WEST SUSSEX COUNTY COUNCIL CONSULTATION

TO:	Arun District Council FAO: Maria Tomalova
FROM:	WSCC - Highways Authority
DATE:	26 March 2021
LOCATION:	Land off Canal Mews, Canal Mews, Barnham, PO22 0DP
SUBJECT:	BN/30/21/DOC Approval of details reserved by condition imposed under BN/66/19/PL relating to Conditions 3-External materials and finishes, 4-Screen walls & fences, 6-Details of secure cycle parking, 7-Site set up details, 8-Details of electric charging of vehicles, 16-Details of decentralised and renewable energy, 19-Landscaping scheme and 20-details of existing tree protection,
DATE OF SITE VISIT:	N/A
RECOMMENDATION:	Advice
S106 CONTRIBUTION TOTAL:	N/A

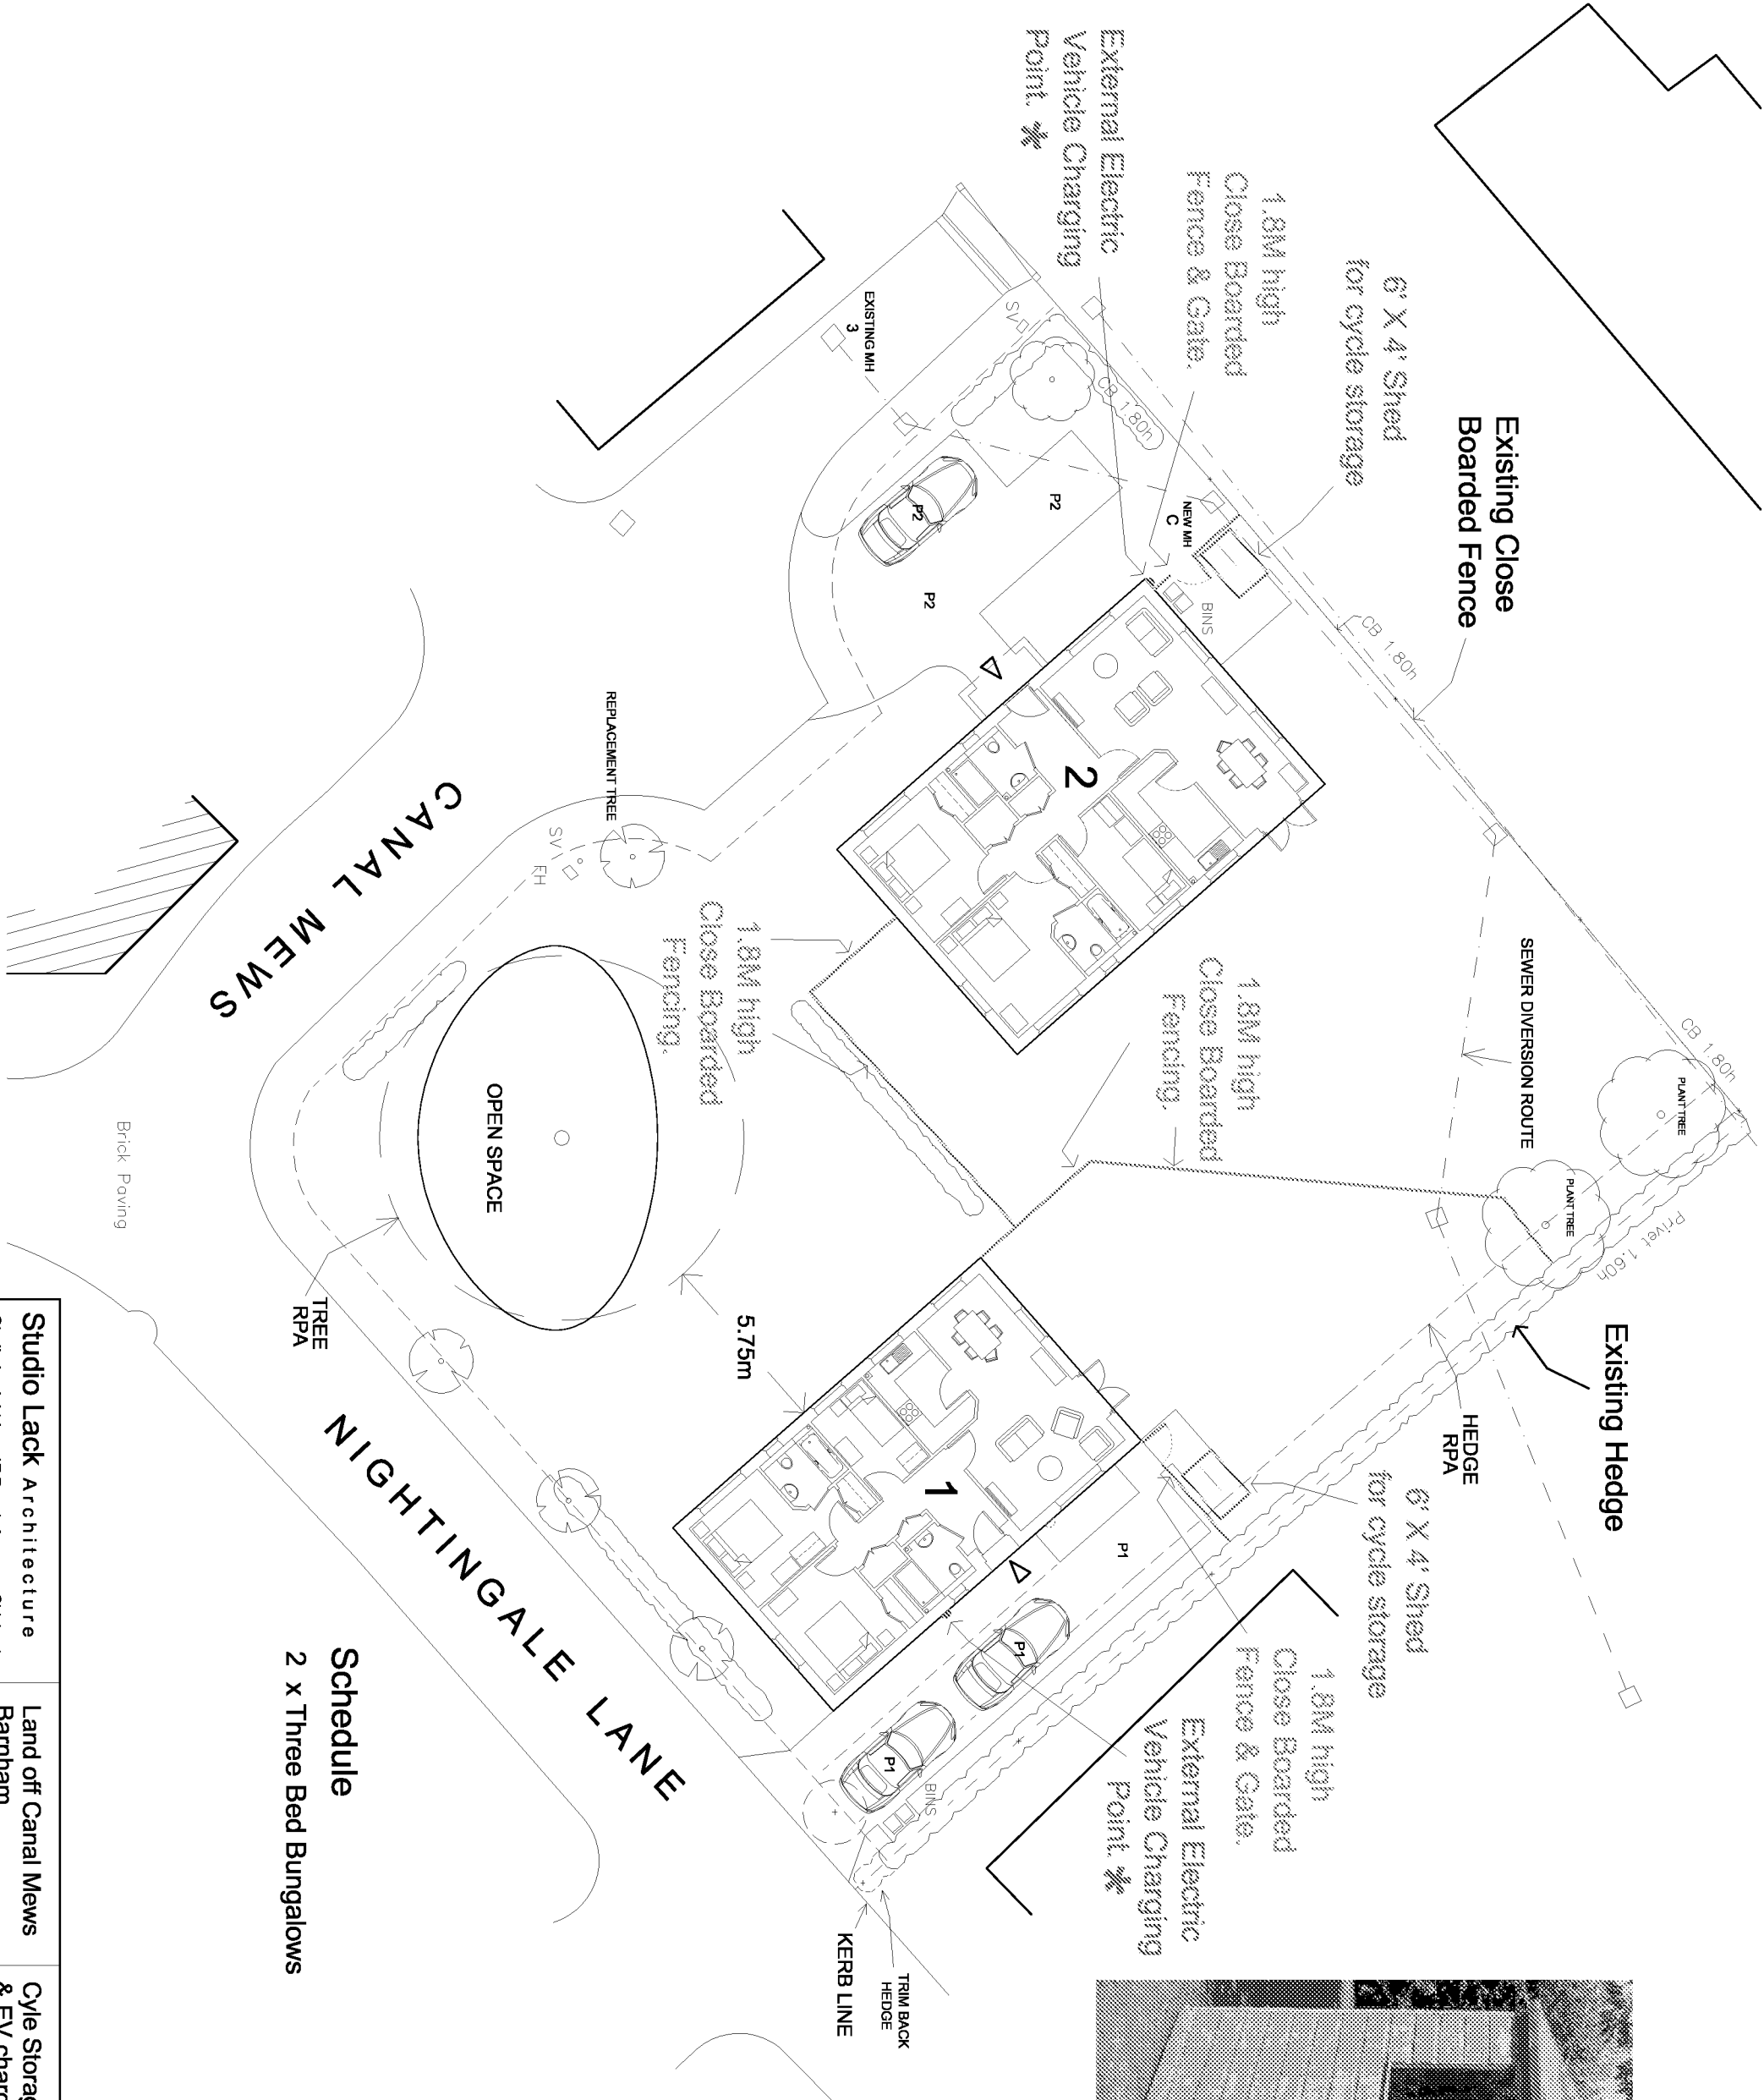
The applicant has submitted a site plan, demonstrating the location of cycle sheds for both dwellings, in accordance with WSCC and Arun Parking Standards. The LHA is satisfied that Condition 6 can be discharged.
